OAKLANDS FARM SOLAR PARK

Applicant: Oaklands Farm Solar Ltd

The Applicant's Comments on Written Representations and other
Deadline 1 submissions

Document Ref: EN010122/D3/11.2

Indicative Abnormal Load Swept Path Analysis

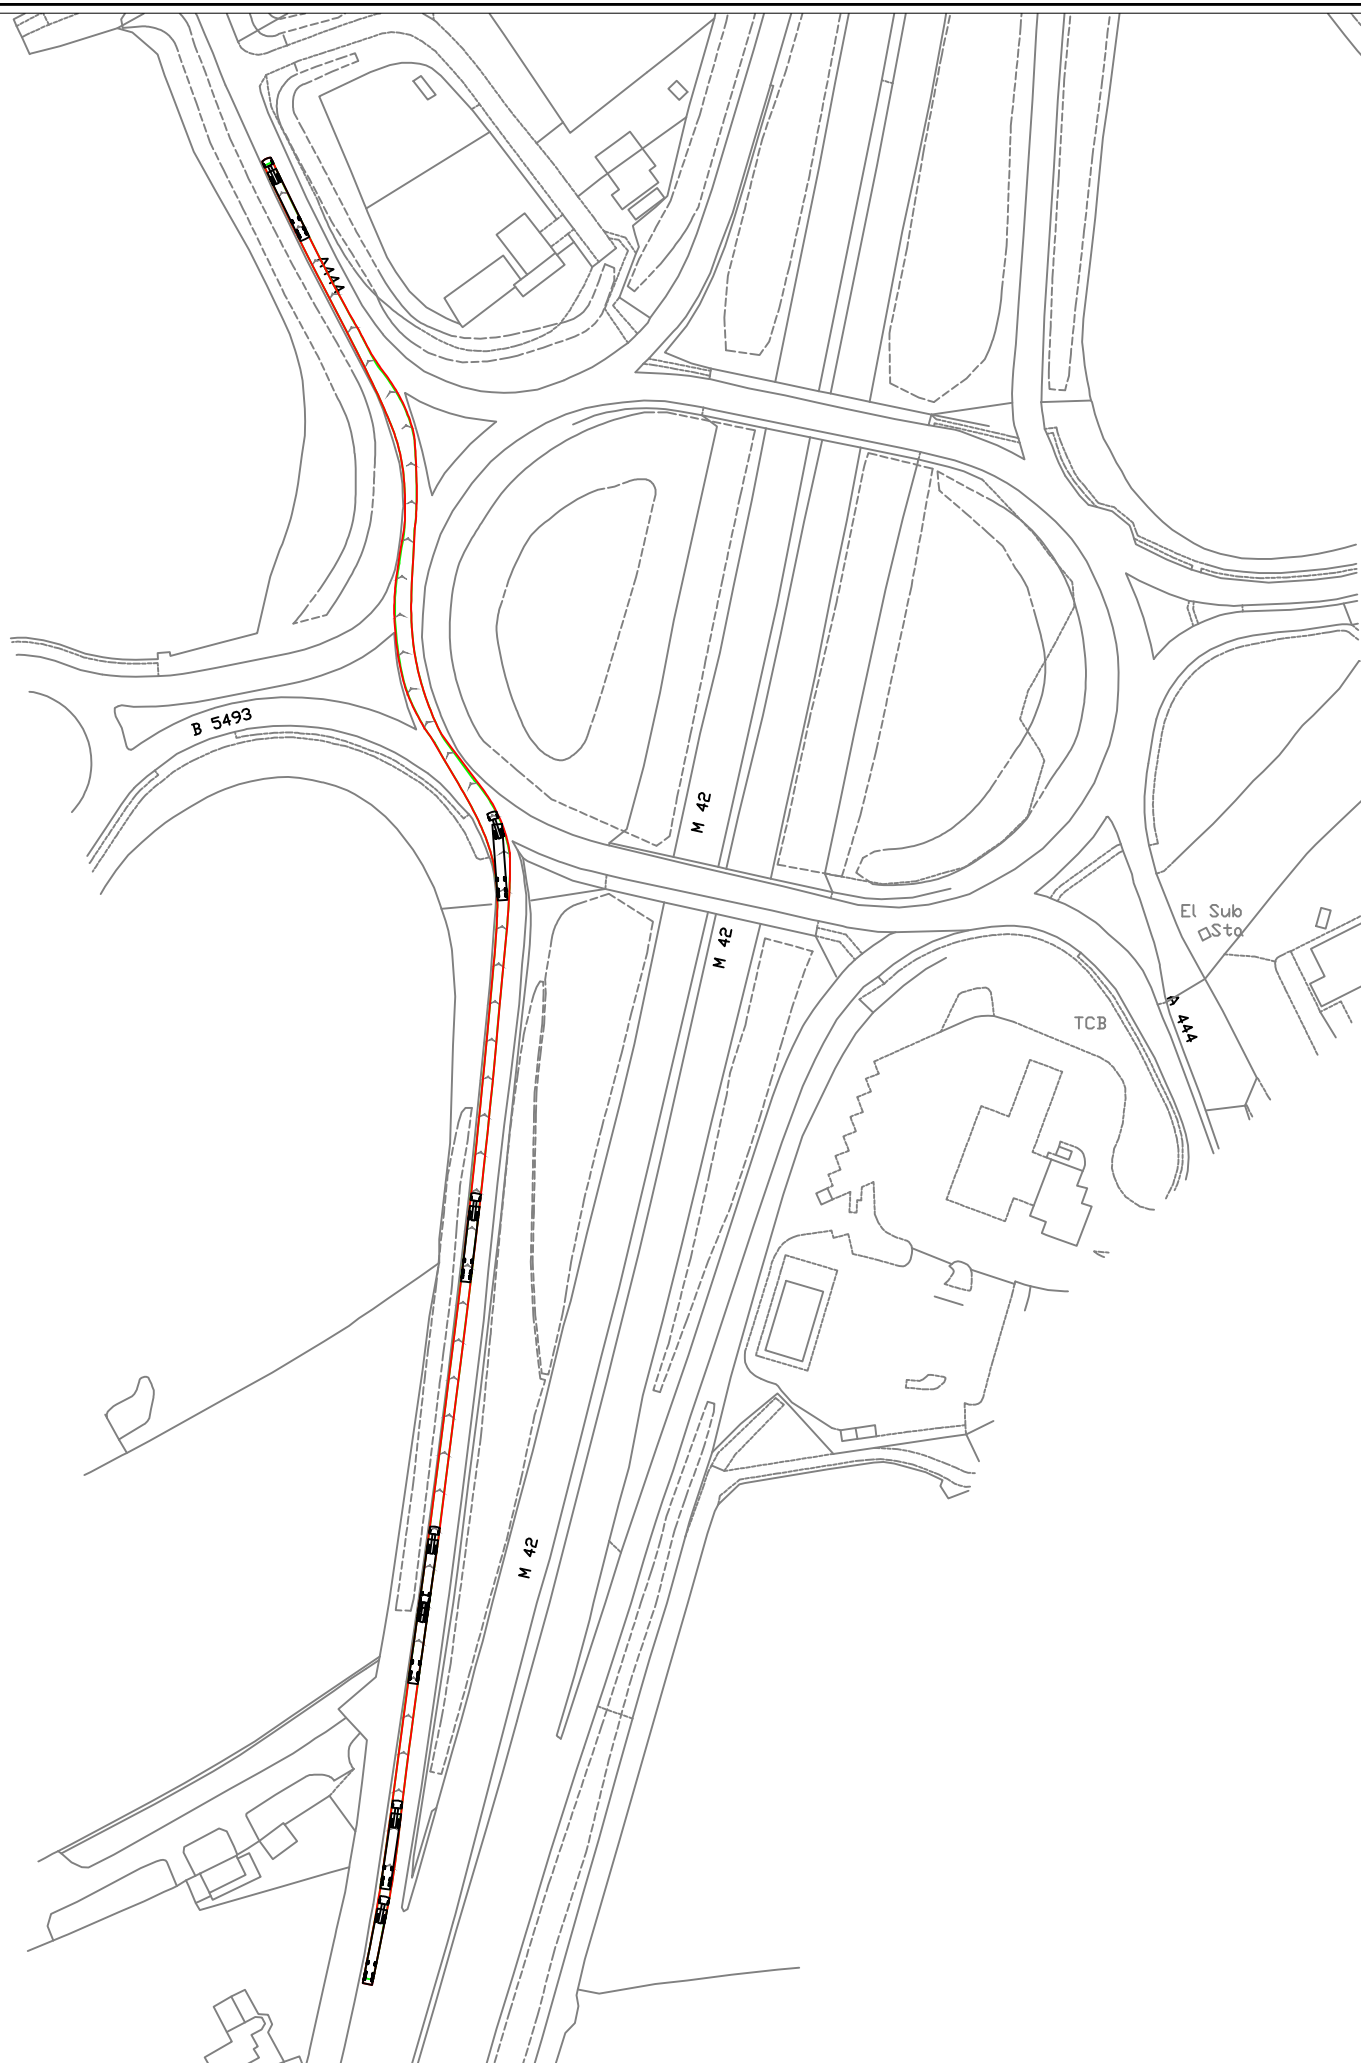
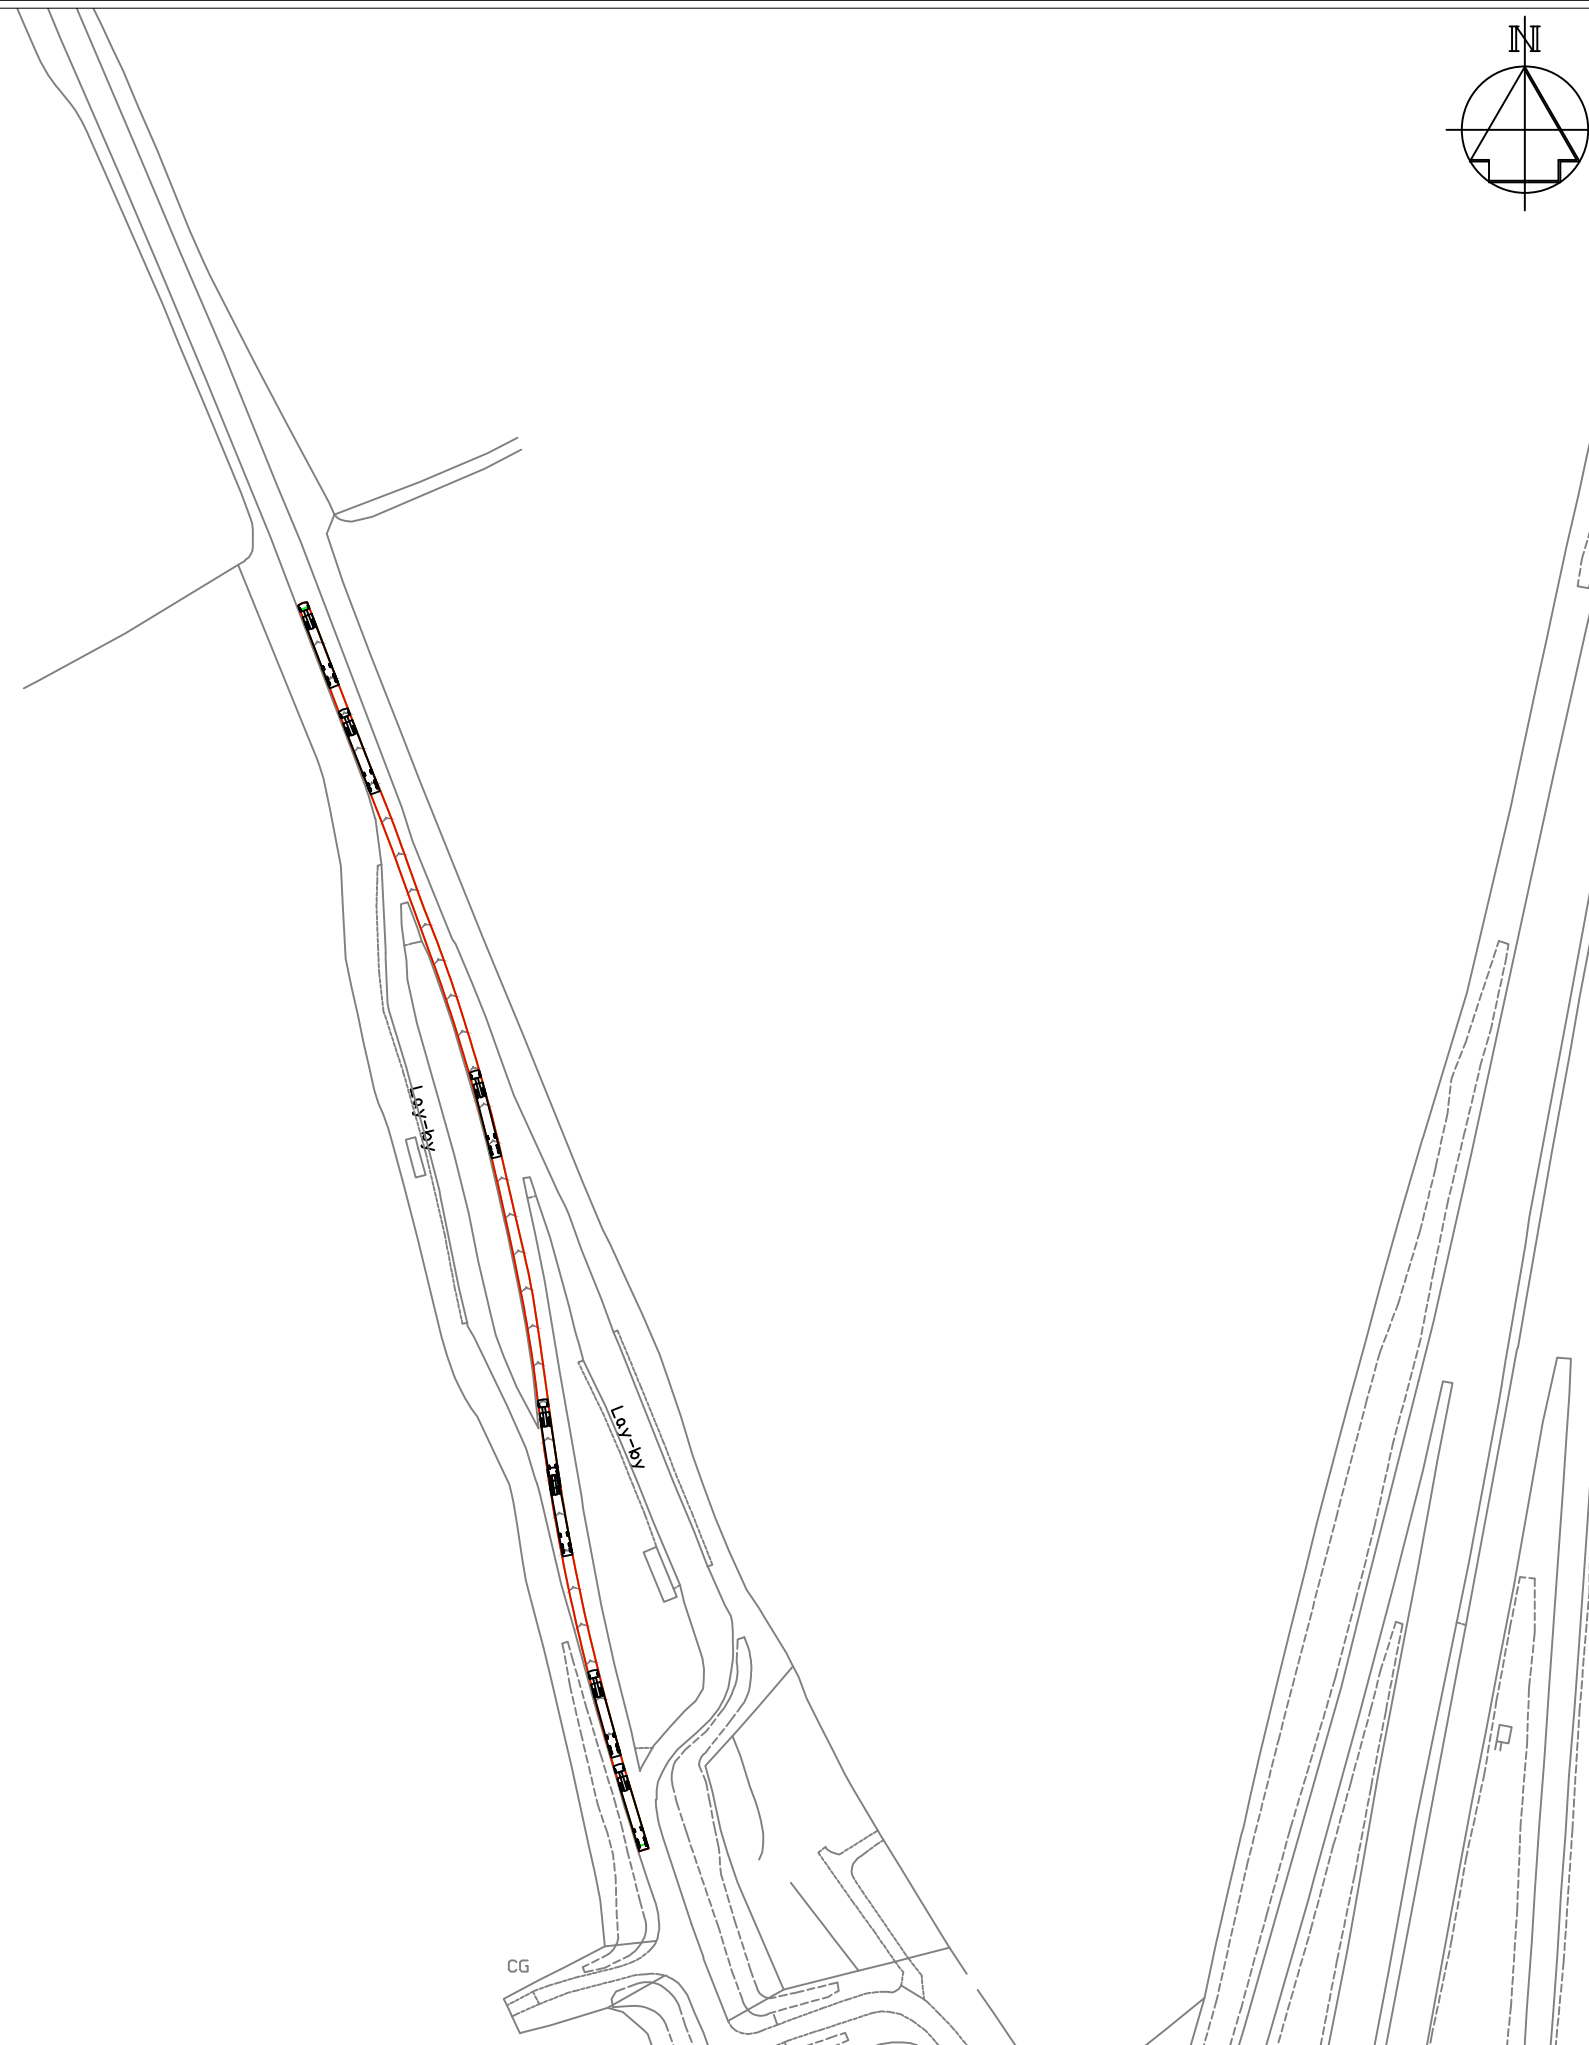
THEME	COMMENT	APPLICANT RESPONSE
Transport	<p>The submitted Environmental Statement (APP-155) states that AIL are proposed to use the Leicestershire Local Road Network (LRN) (A444) between the M42 and Acresford. Whilst these AIL movements are predicted to be limited in number to two (APP155, paragraph 10.154), and are proposed to be Police escorted (APP-155, paragraph 10.156), the submission identifies that surface protection, culvert reinforcement, and temporary removal of street furniture will be required at locations along the route (APP-155, paragraph 10.157).</p> <p>However, the extent and location of such work within the public highway in Leicestershire is unclear. The supporting swept path analysis (APP-154) of which drawing numbers DWG/3299/001 - DWG/3299/005 are relevant to Leicestershire, is labelled as indicative and includes a drawing note which simply states, 'specific vehicle configuration to be checked by specialist haulage company'. Furthermore, the drawings do not appear to be based on a topographical survey and therefore don't identify street furniture etc; neither do they indicate locations of structures e.g., culverts.</p> <p>LCC therefore request that the Applicant engages at the earliest opportunity within this Examination process and confirms the vehicle specification, the associated highway impacts, and the necessary mitigation measures on the LRN in Leicestershire.</p>	<p>The Chapter 10 (Transport and Access) of the Environmental Statement (ES) [APP-155] has assessed the environmental effects for Abnormal Indivisible Loads (AIL). Abnormal load mitigation measures will be secured under Requirement 10 (construction traffic management plan) of the Draft Development Consent Order (dDCO) [REP1-003] in a detailed Construction Traffic Management Plan (CTMP). There is also a legal requirement on the Applicant under the Electronic Service Delivery for Abnormal Loads (ESDAL) system to provide mitigation.</p> <p>The AIL movements will be subject to a separate application and permitting scheme, currently administered by National Highways in consultation with the relevant highway authorities and police. This process will be supported by additional route assessment and validation, including additional surveys as required. Arrangements for further consultation, liaison and monitoring are included in the Outline Construction Traffic Management Plan (OCTMP) [REP1-021].</p> <p>The details of the AIL movements will be confirmed at the detailed design stage once the vehicle specifications are known and the extent of the AIL can be fully assessed in detail. As set out in the OCTMP suitable mitigation measures that will be provided, include:</p> <ul style="list-style-type: none"> • Advanced notification of AIL movement to local residents and businesses. • Temporary Traffic Regulation Order to ensure route remains unobstructed of parked vehicles. • Movement undertaken at a specific time of day in a rolling roadblock format, supported by a police escort to limit the magnitude of impact on identified sensitive receptors. • AIL supported by an escort vehicle along the entirety of its route to warn vehicles and allow the AIL enough time to navigate bends and turns.

<ul style="list-style-type: none"> • Suitable reinforcements of identified culverts within Coton in the Elms, informed by a DCC approved structural engineer report. • Surface padding to protect any areas of overrun including kerbs and verges. <p>The Applicant will be engaging further with LCC during the course of the Examination regarding the detailed CTMP and AIL Swept Path Analysis.</p>
Transport	The Applicant should be aware that the A444 is a Diversion Route for Unplanned Events (DRUE) on the Strategic Road Network (M42) and consideration should be given when planning and programming abnormal load movements.	The Applicant welcomes this comment and will ensure this is included in the detailed CTMP.
DCO	LCC seeks protection of its assets and recovery of any associated costs through provisions within the Development Consent Order. The draft as submitted (APP-016) does not appear to contain the necessary provisions. Indeed, no reference is made to Leicestershire.	The Applicant is required to remediate any damage to the highway network under the CTMP secured by Requirement 10 of the dDCO [REP1-003] . The Applicant will continue to engage with LCC regarding its representation and will provide an update to the ExA at Deadline 4.

Transport	<p>LCC has concerns about the potential impact of AIL movements associated with this development proposal on the LRN within Leicestershire. The information submitted in support of the application is lacking in this regard.</p> <p>LCC note from our attendance at the Preliminary Meeting held on 10th July 2024 that there was a commitment from the Applicant to engaging with Interested Parties, and LCC would welcome engagement as soon as possible to address these concerns.</p>	<p>The details of the AIL movements have been fully assessed within Chapter 10 (Transport and Access) of the ES [APP-155]. The proposed mitigation is set out in the OCTMP [REP1-021] and the final detailed mitigation will be secured in the detailed CTMP as part of Requirement 10 (construction traffic management plan) of dDCO [REP1-003].</p> <p>The Applicant will be engaging further with LCC during the course of the Examination.</p>
